Response to Issues – Department of Planning and Environment

21 Honeysuckle Drive, Newcastle – SSD 8019

2.1 Communal Open Space Percentages

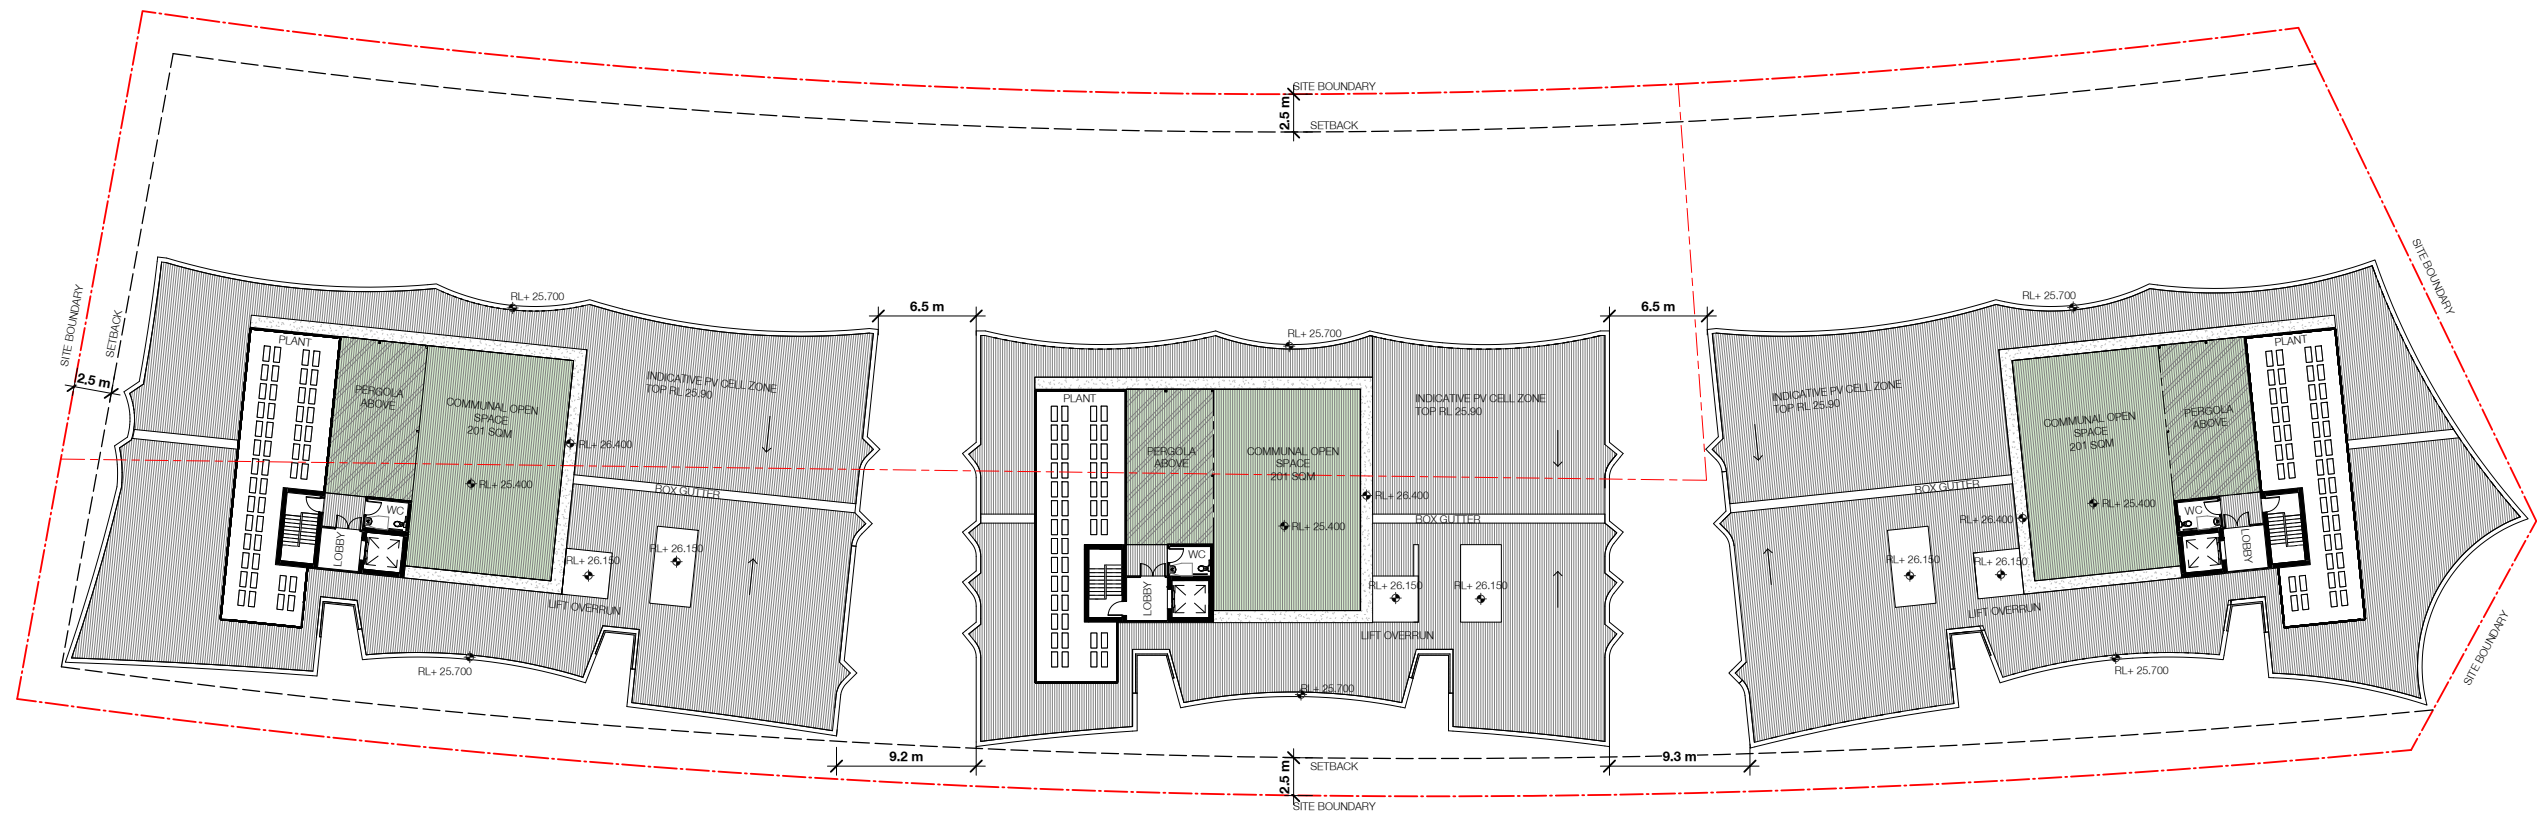
Particulars of Issues	Response	Attachment
Residential Amenity		
<i>While the Department acknowledges the site is located adjacent to Worth Place Park West, private communal open space is an important component of any medium to high density development. Although three (3) areas of communal open space are provided on ground level, these areas are both small in size and disconnected. The communal open space should be reconsidered, including options to increase the overall amount of space, improve access to residents and the potential co-location of facilities to encourage use of these spaces.</i>	Following further discussion with DP&E, a comprehensive review of the communal open space of the proposed development was undertaken. In order to improve the amenity for future residents, communal open space areas totalling 603m ² are proposed at main roof level to each building. In conjunction with the originally proposed ground floor communal areas, the revised scheme provides a total of 923m ² of communal open space, which is equivalent to 12.5% of the site area.	Refer to: <ul style="list-style-type: none"> Attachment 1: Revised Architectural Drawing Package; Attachment 2: Built Form Analysis; and Attachment 3: Clause 4.6 Variation.
